**WELWYN HATFIELD BOROUGH COUNCIL
EXECUTIVE DIRECTOR - PLANNING, PUBLIC PROTECTION AND GOVERNANCE**

DELEGATED APPLICATION

Application No: 6/2017/1069/HOUSE
Location: 19 Theobalds Road Cuffley Potters Bar EN6 4HQ
Proposal: Erection of single storey rear extension and installation of dormer windows to facilitate loft conversion to habitable space
Officer: Mr D Elmore

Recommendation: Granted

Proposed Ground Floor Plan

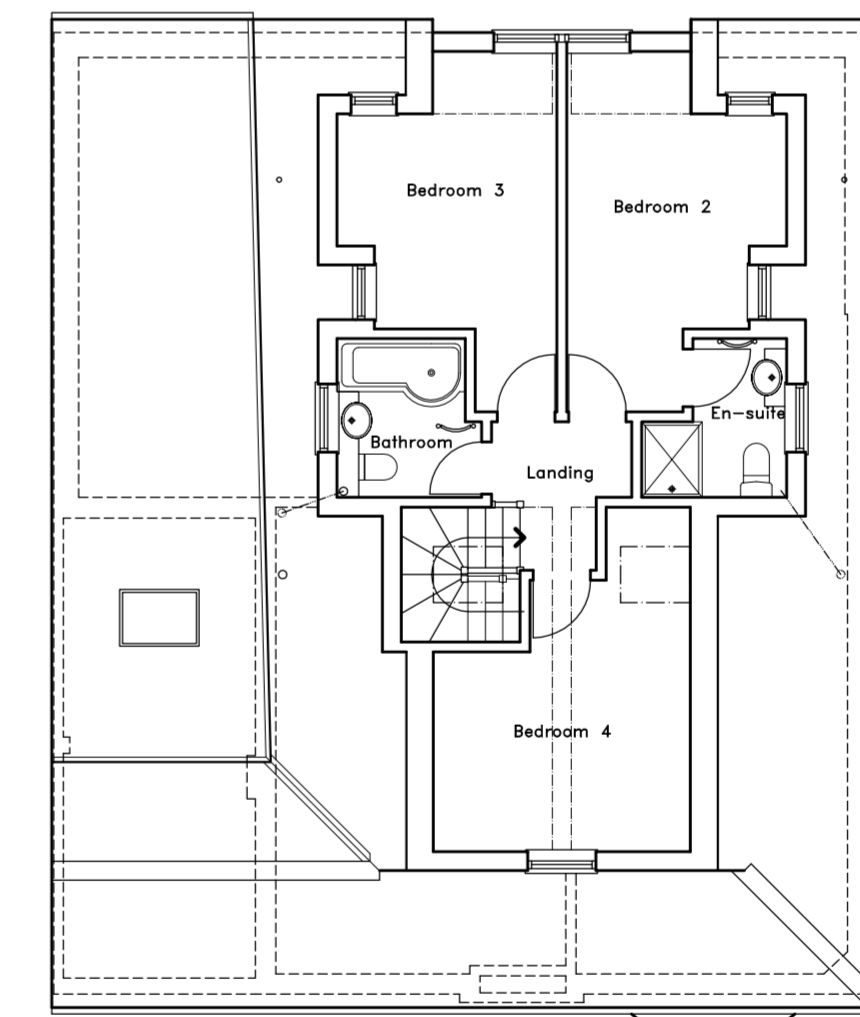
A 4-bed dwelling in this location would require a guideline provision of 3 off-street car parking spaces. In order to facilitate this, the front driveway would be extended for an additional 2 spaces and an integral garage would be created.

The integral garage would measure 6.2m long by 2.5m wide. Although the width is short of government guidance which outlines that new garages should measure 6m long by 3m wide, this is not to say that a smaller vehicle could be sufficiently parked within it. It is also noted that the extended driveway could serve 3 cars.

In light of the above, it is considered that the level of off-street parking provision provided is in accordance with the Council's car parking guidance, and is therefore considered to be acceptable for the development.

Proposed First Floor Plan

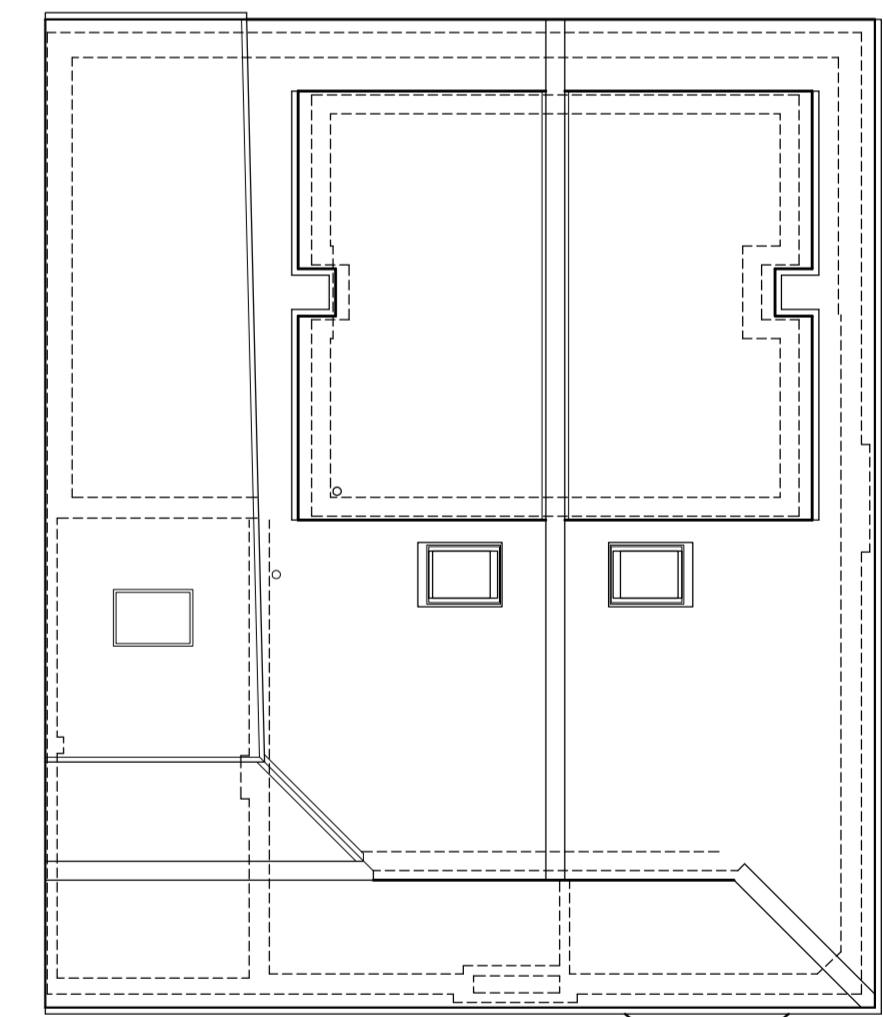
In terms of privacy, 2 windows in the dormer (serving a bathroom and bedroom) and roof light (serving bedroom) would face the dormer windows of this neighbouring property. In the interest of maintaining levels of privacy, it is considered necessary and reasonable for the dormer windows to be glazed in obscure glass and have a restricted level of opening. This can be secured through planning condition. The proposed roof light would be installed high on the roof slope and therefore would not present any overlooking.

2. The dormer windows facing numbers 17 Theobalds Road and 21 Theobalds Road must be glazed with obscured glass and shall be fixed so as to be incapable of

being opened below a height of 1.7 metres above floor level, and shall be retained in that form thereafter.
